Subject: FW: HVPC Reponse Planning application: Erection of detached dwelling at Springwood House, Sheffield Road, New Mill, Holmfirth HD9 7EX - 2020/93986
Date: 10 February 2021 12:06:04

Re. Springwood House

SECTION A-A

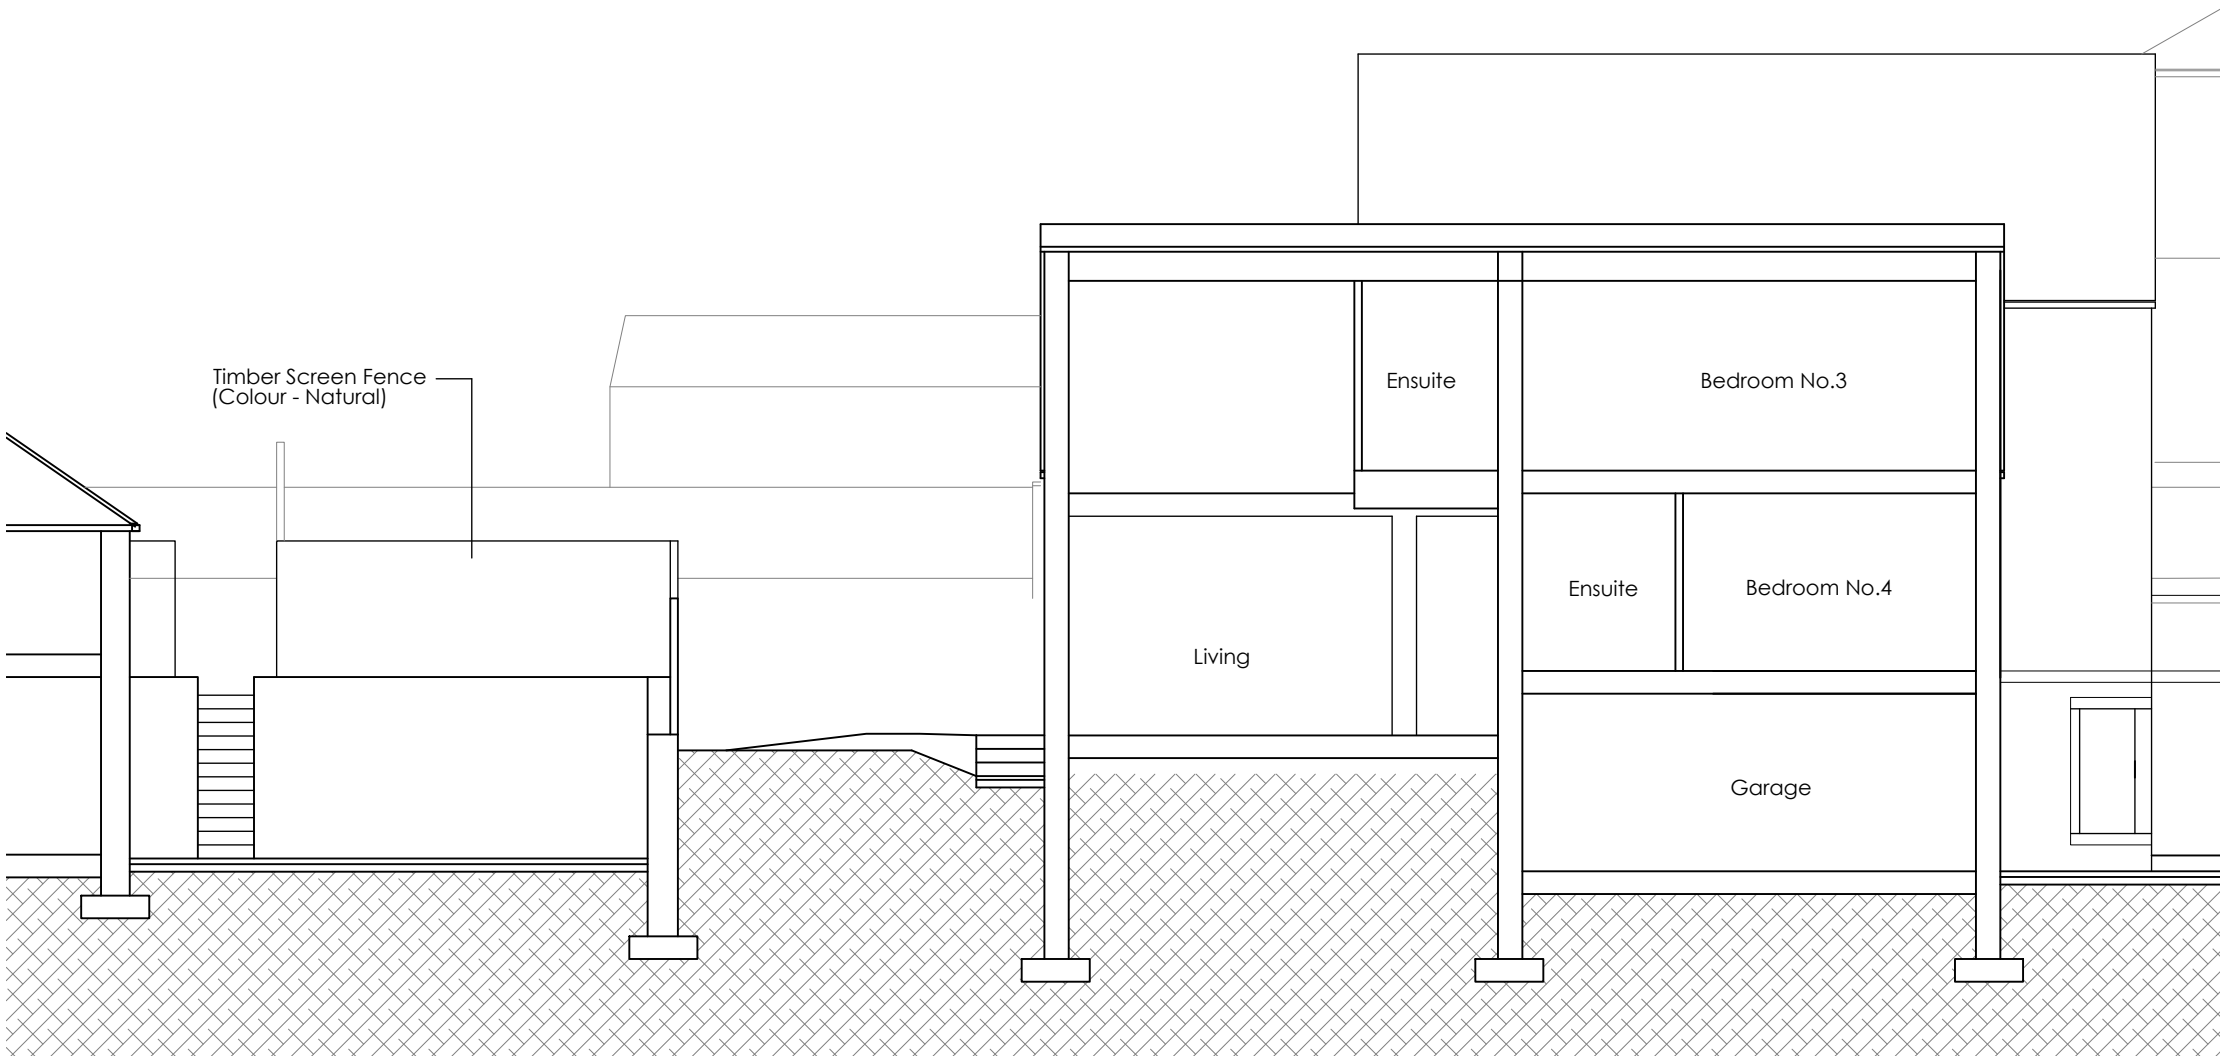
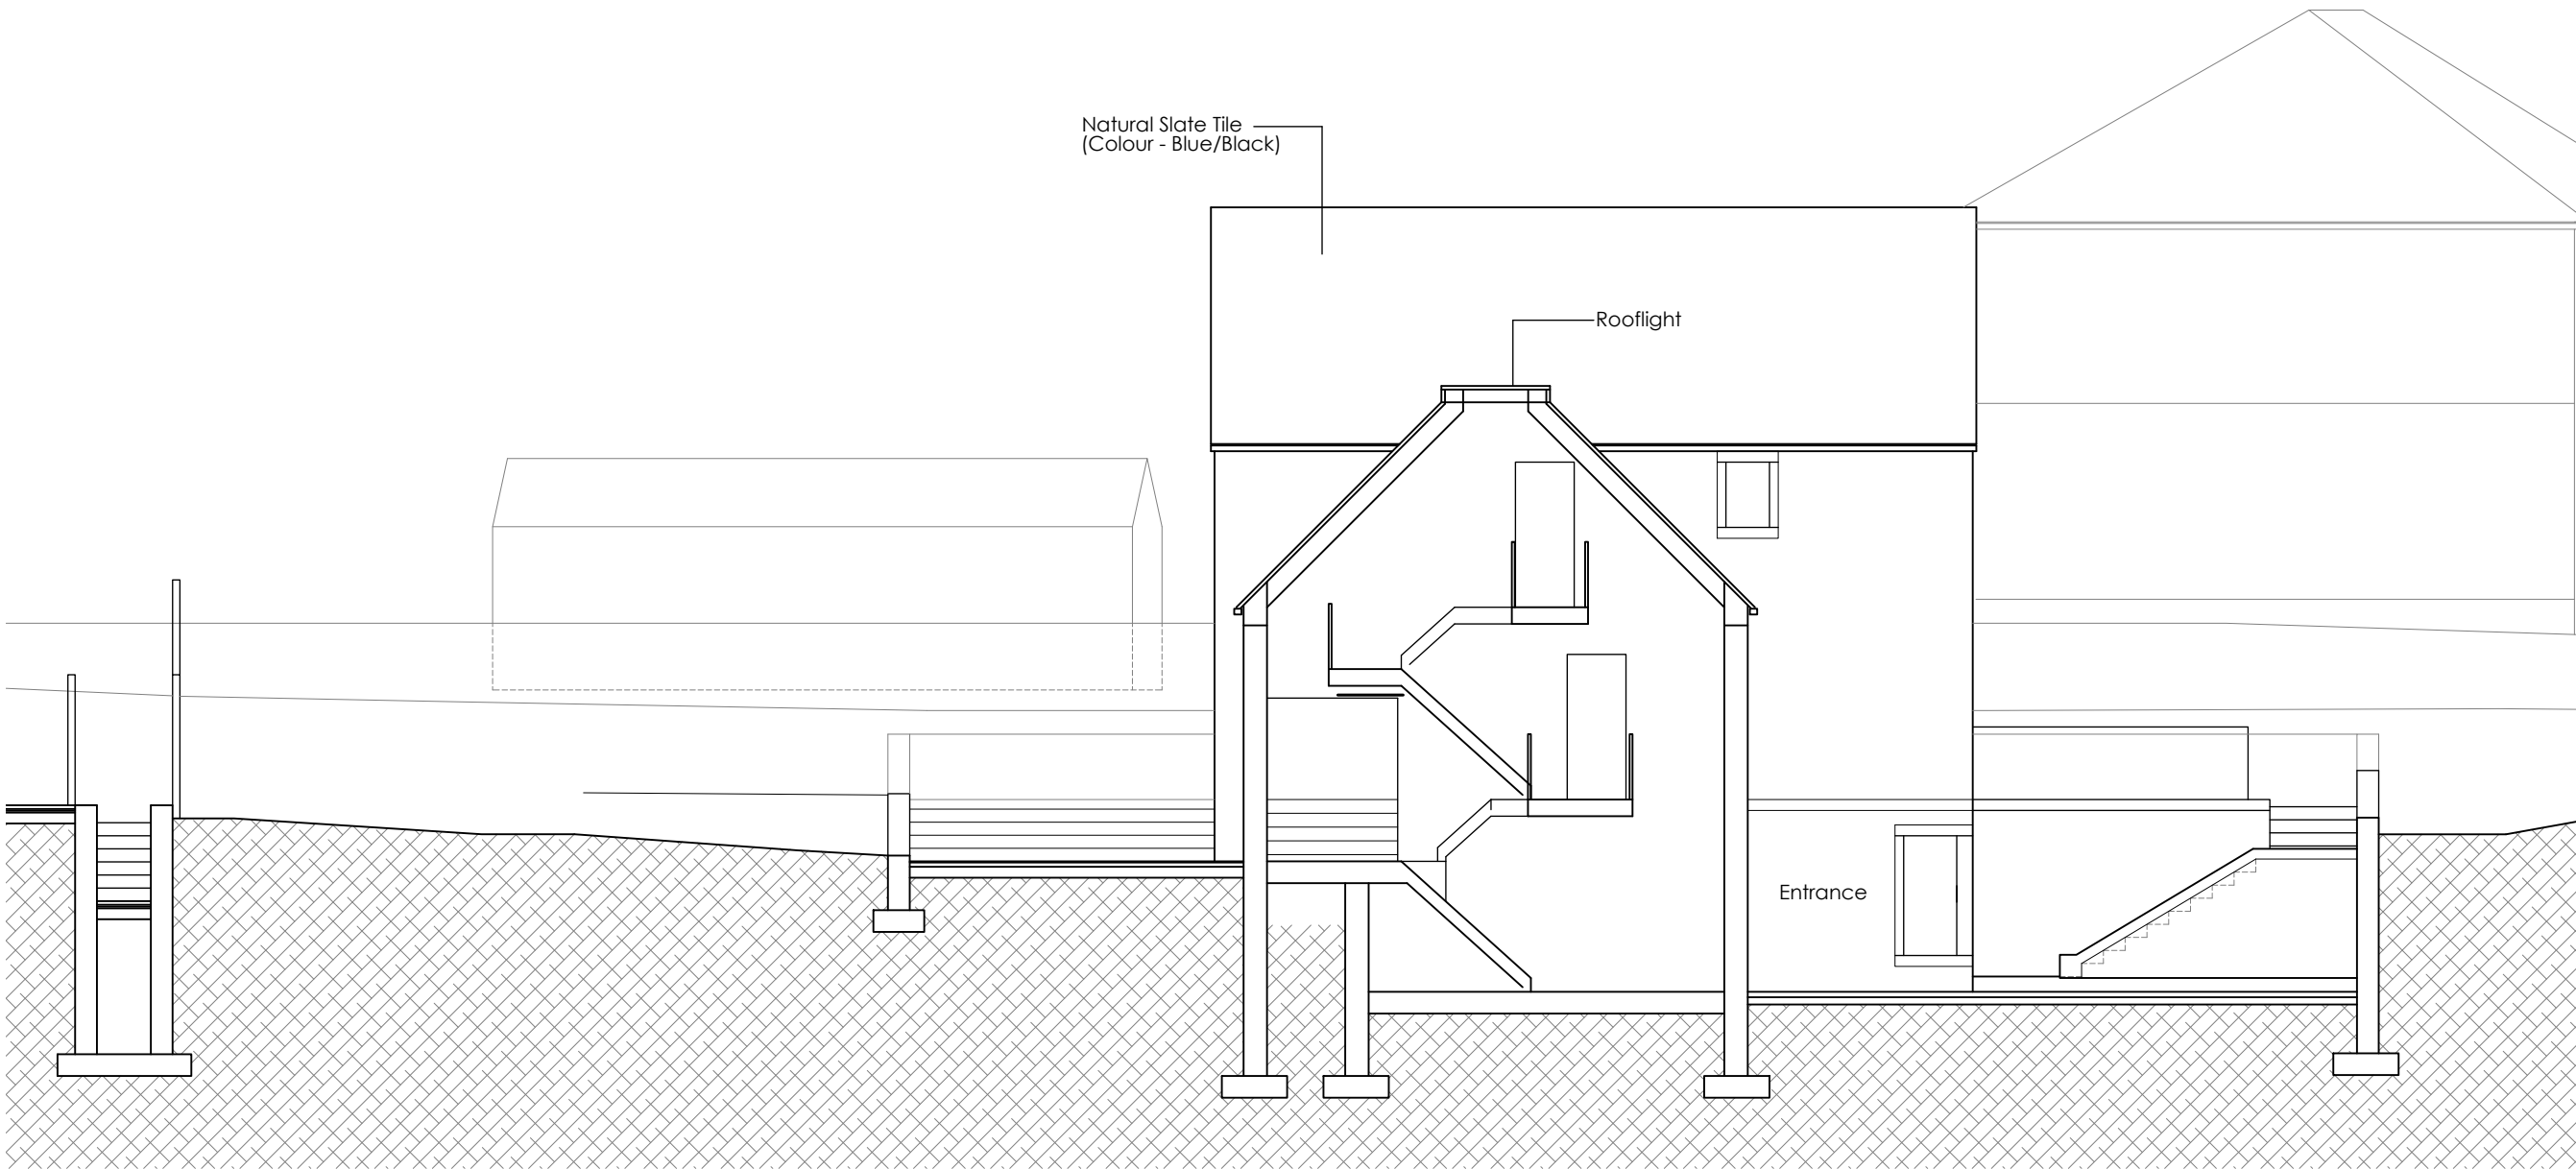
Holme Valley Parish Council's comment is: "Defer to Kirklees Planning Officers but they should acknowledge and address neighbours' concerns regarding overlooking and the height of the building."
